DRB CASE ACTION LOG - BLUE SHEET

Project #: 1010043

Application #: 14DRB-70099

Project Name: Buena Vista

**Plat for  
East Central Gateway Plaza  
Being Comprised of  
Lot E and a Portion of Lot F, Block 7,  
Buena Ventura  
City of Albuquerque  
Bernalillo County, New Mexico  
April 2014**

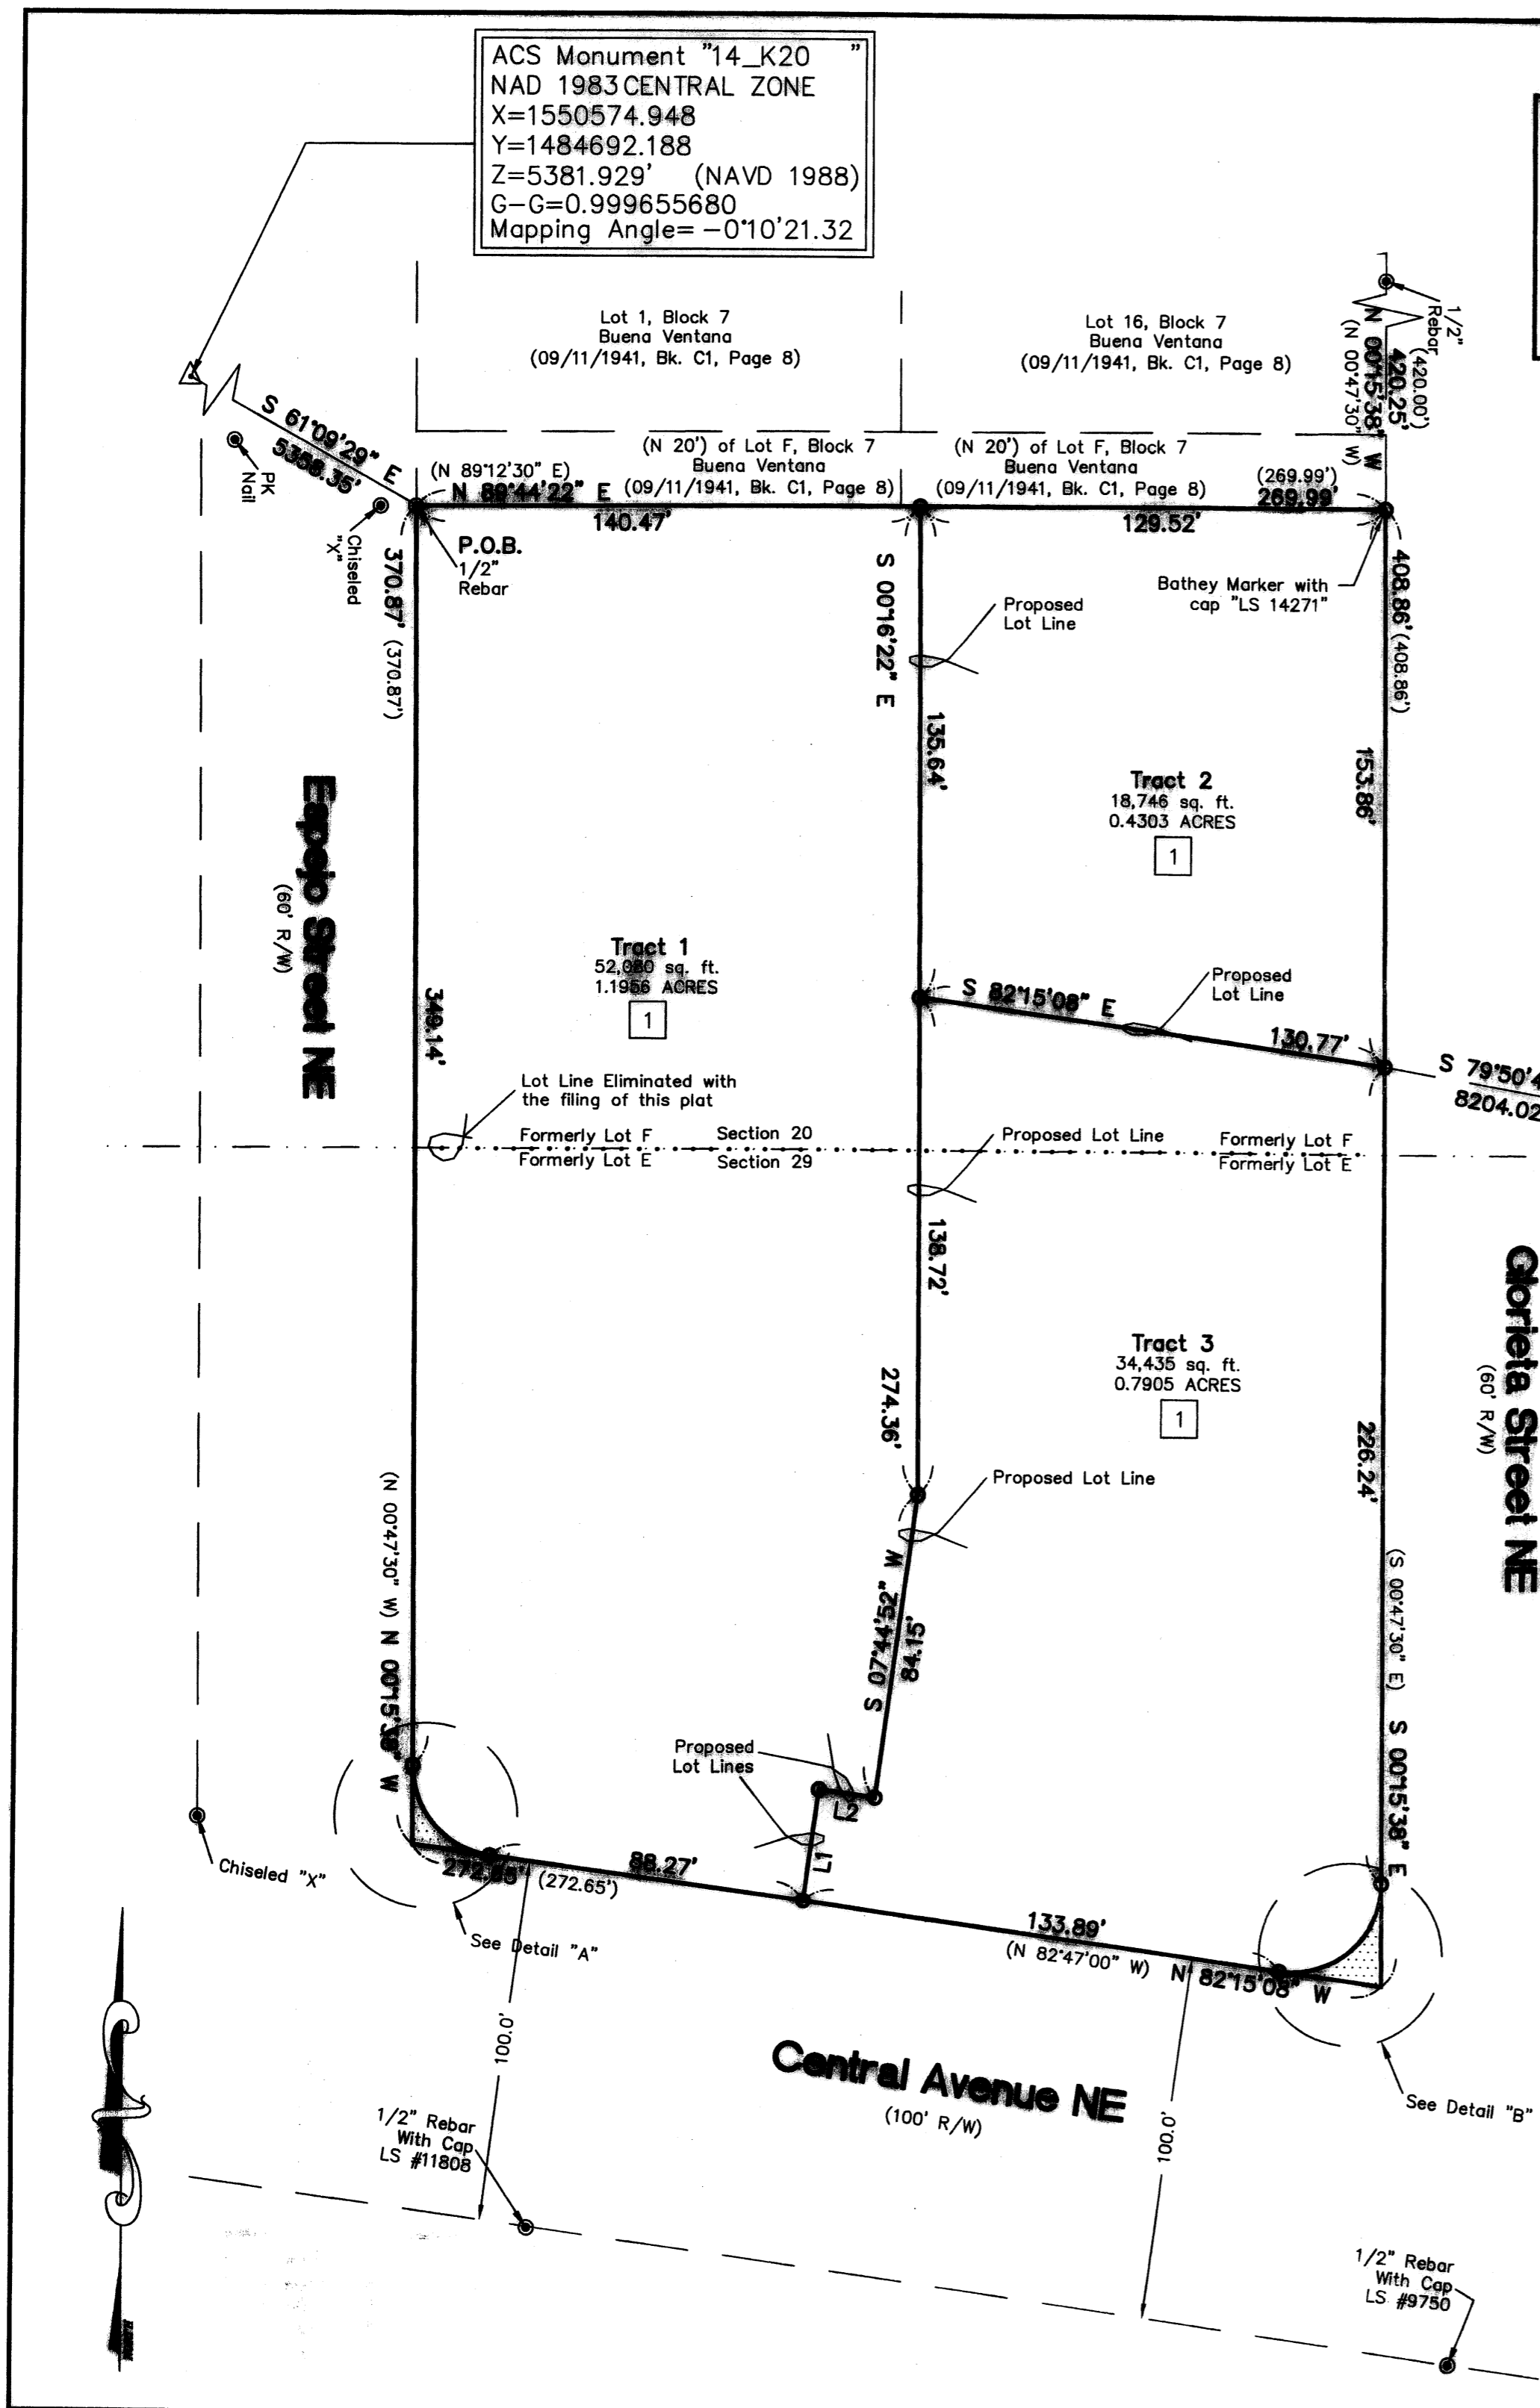
TRANSPORTATION: dedicate R.O.W / Central Ave

PLANNING (Last to sign): update owner's acknowledgment for more R.O.W
with signature of
